e. Detention/Water Quality Criteria

IV. Drainage Facility

b. Water Quality & Detention

DRAINAGE A PLAN & PROFILE

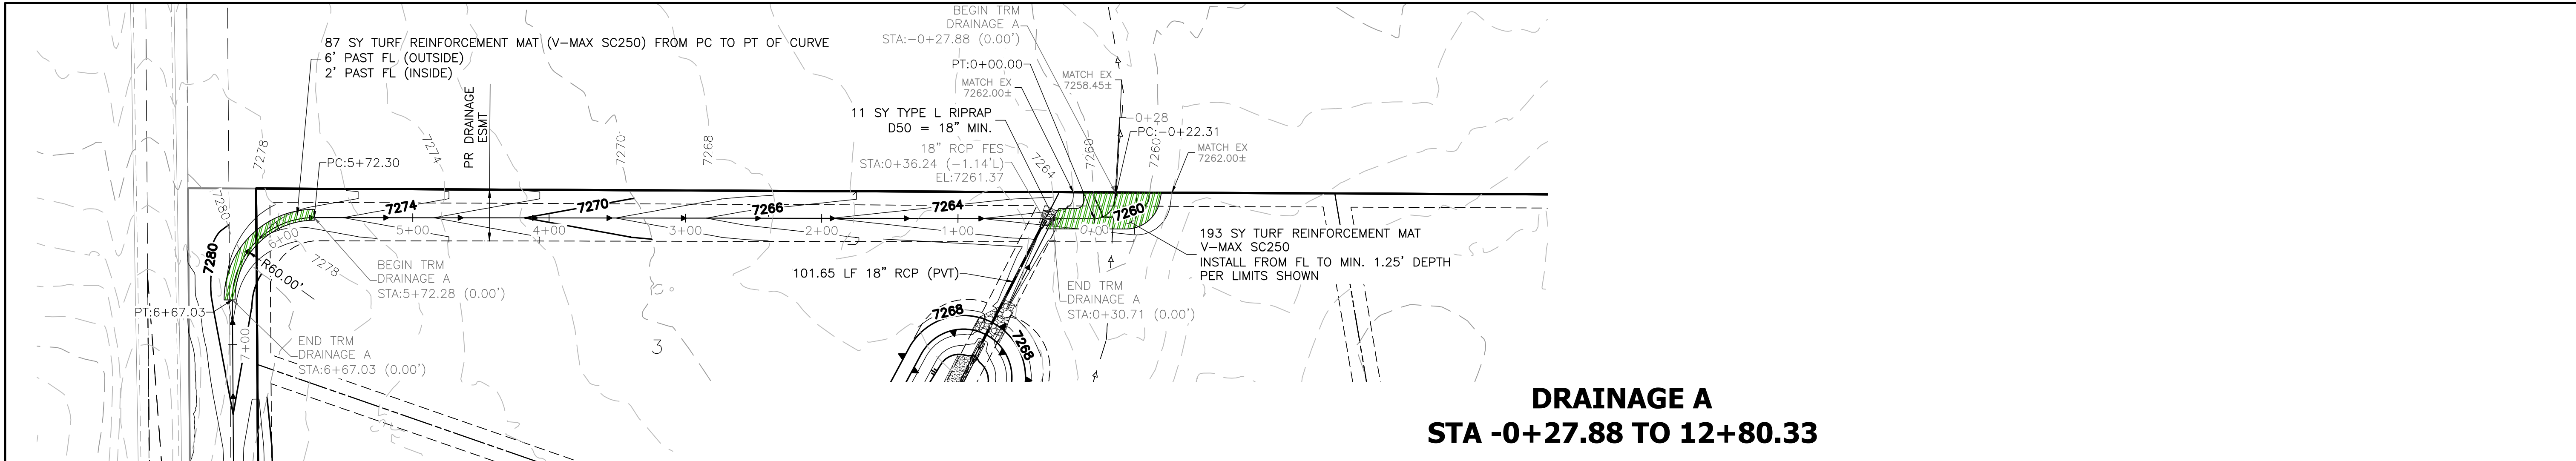
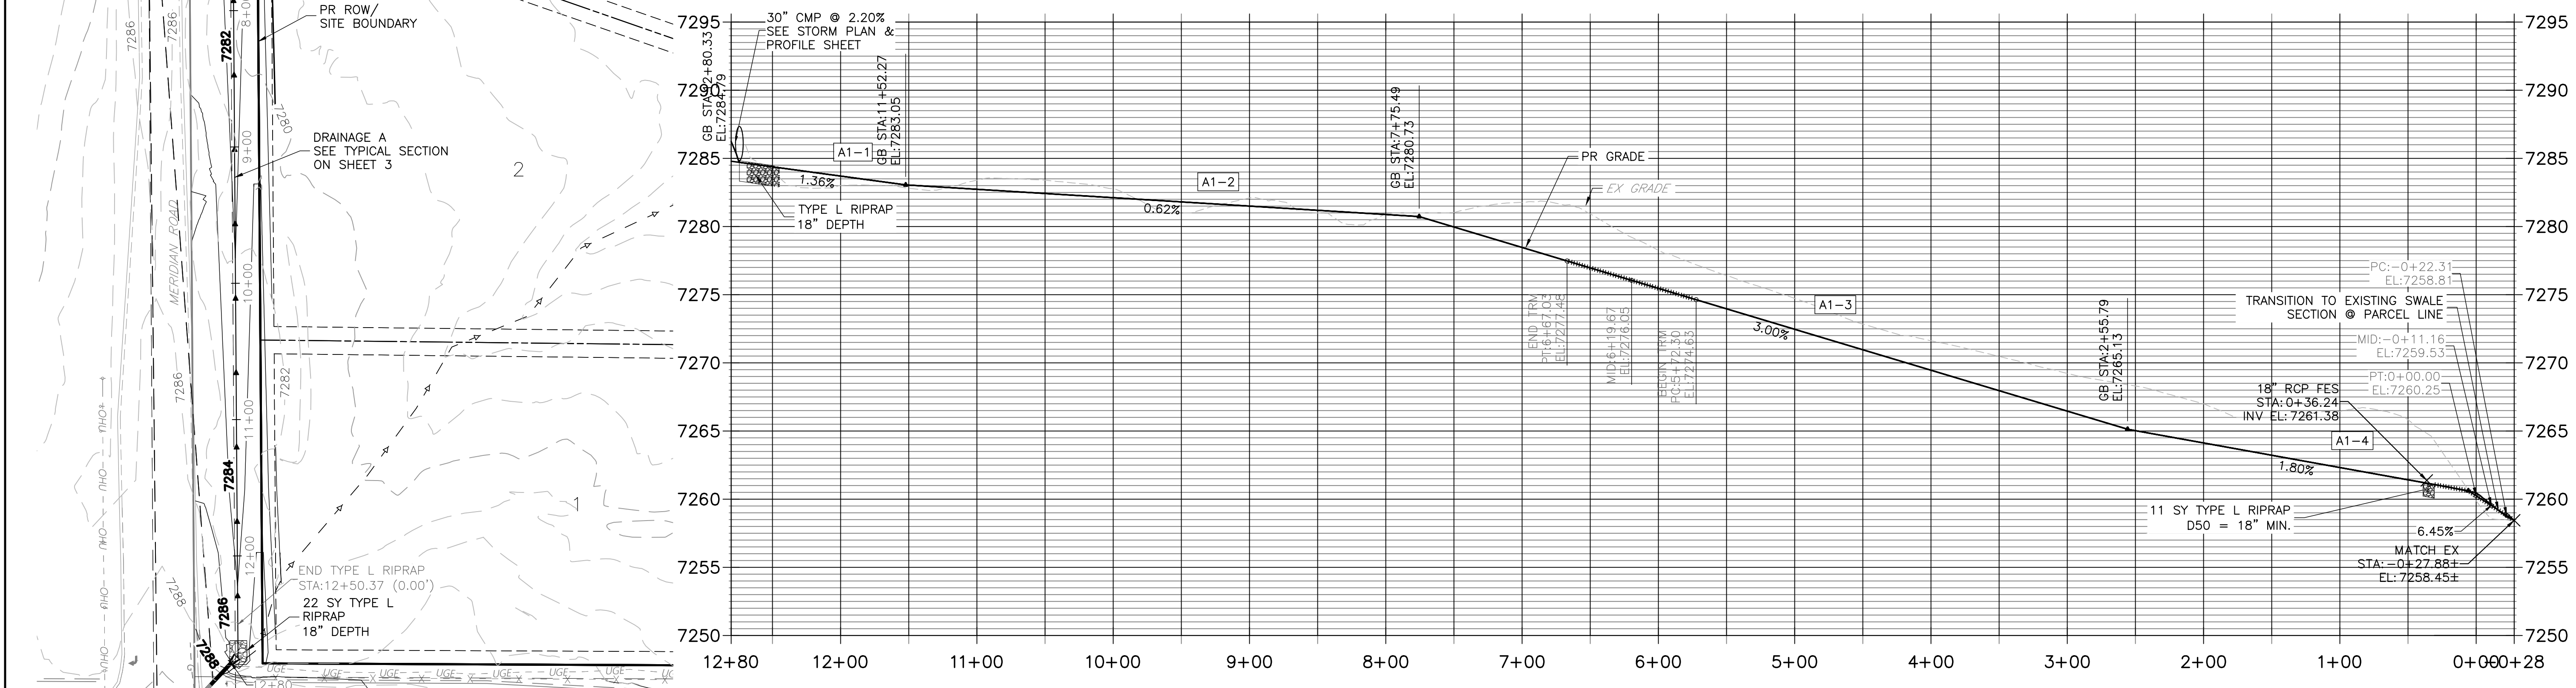
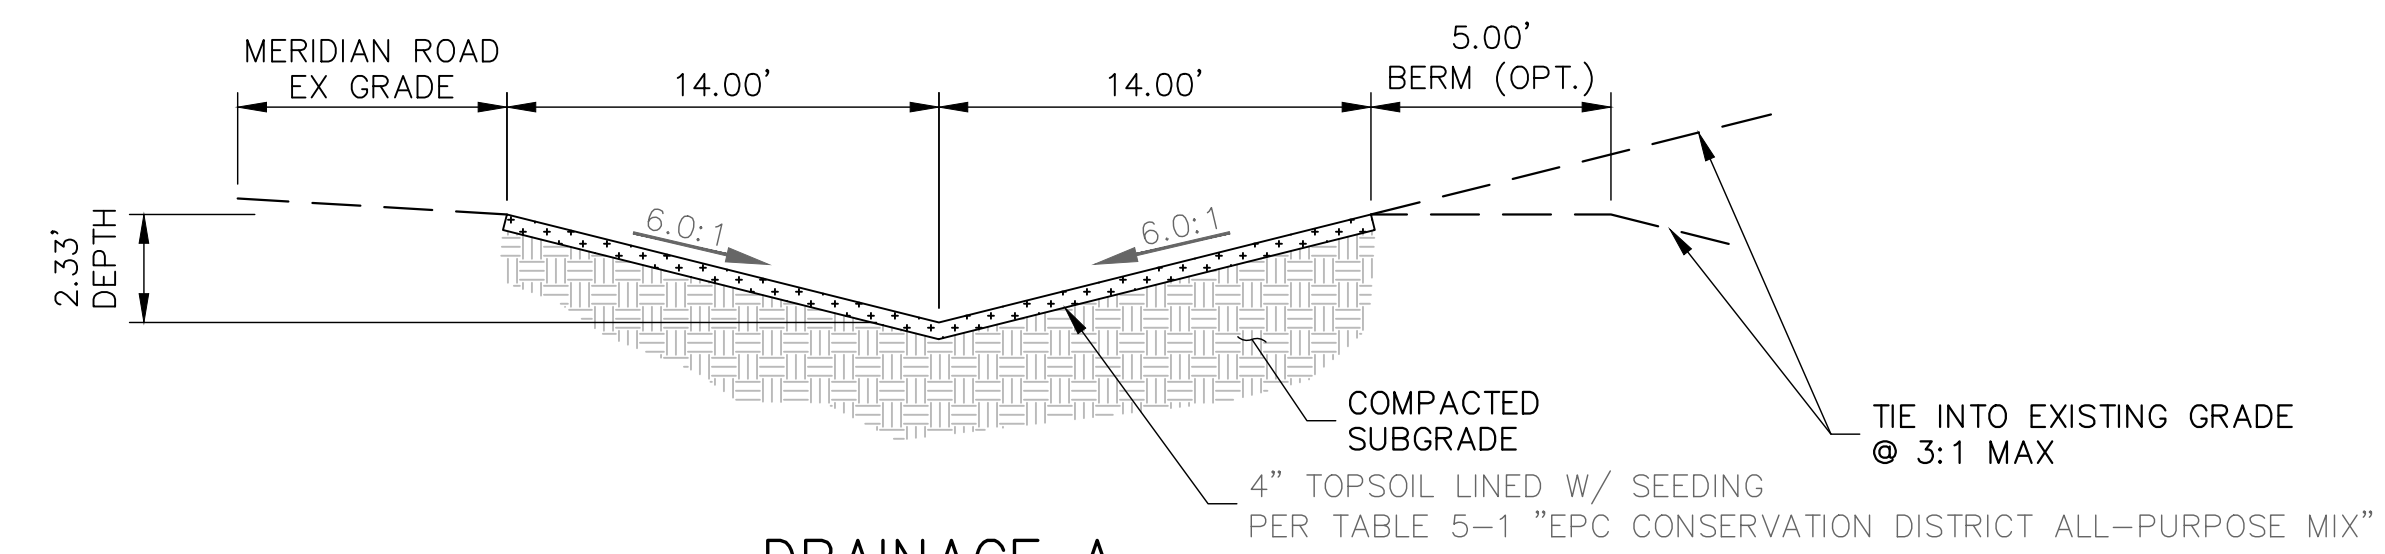
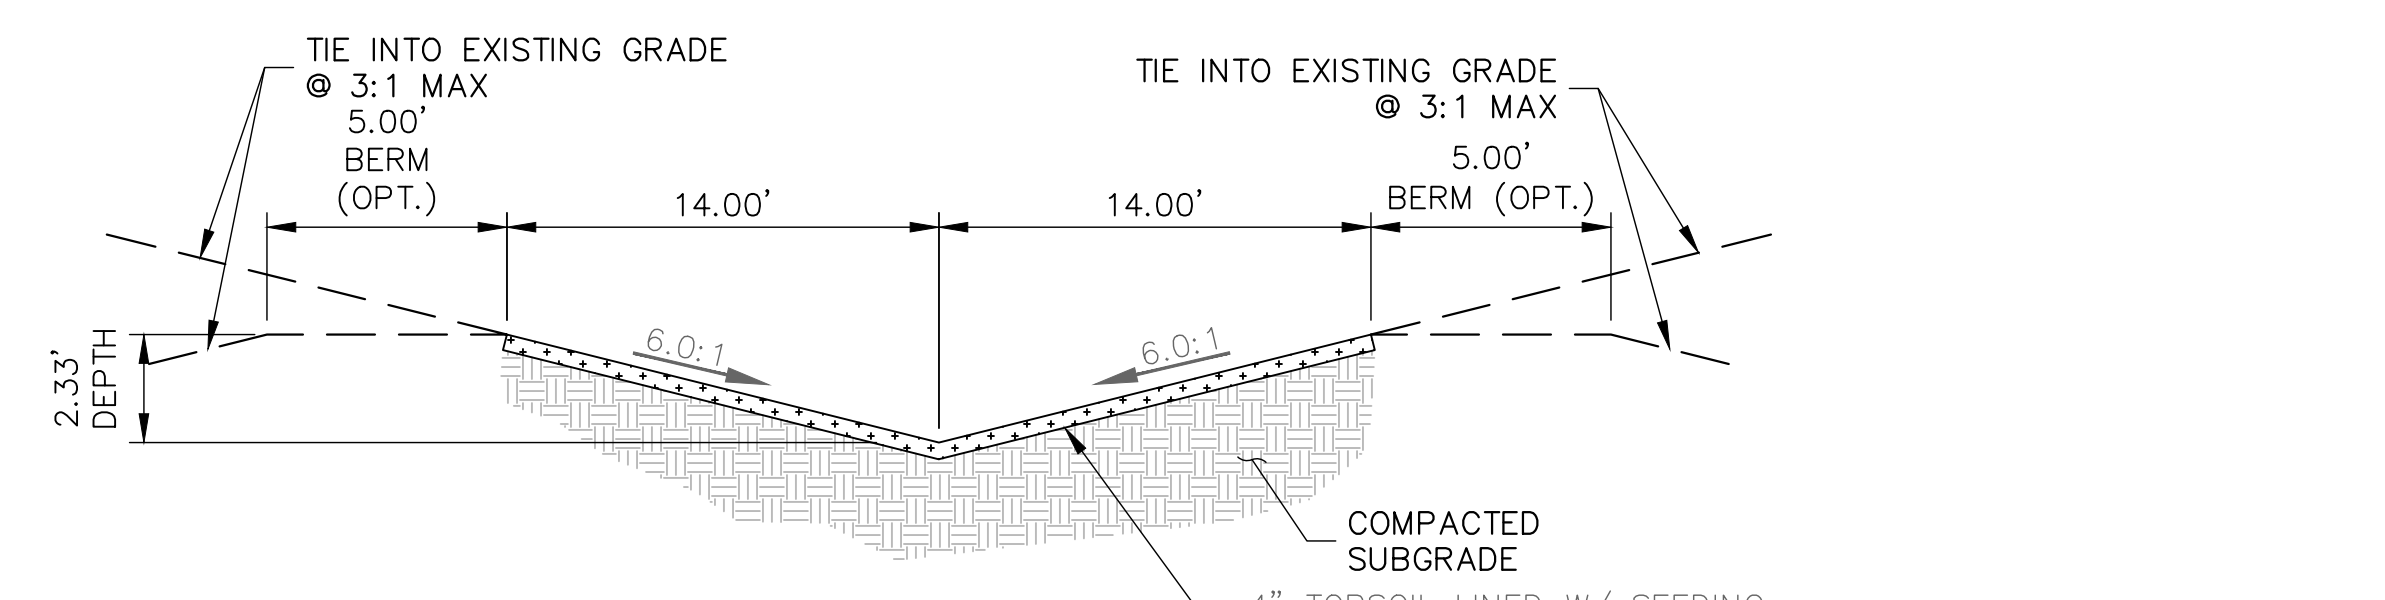
Please include velocities in the swale and discuss the 90 degree bend at the north end of the property and if this area requires any armoring.

please include grass type as max velocity is dependent on type.
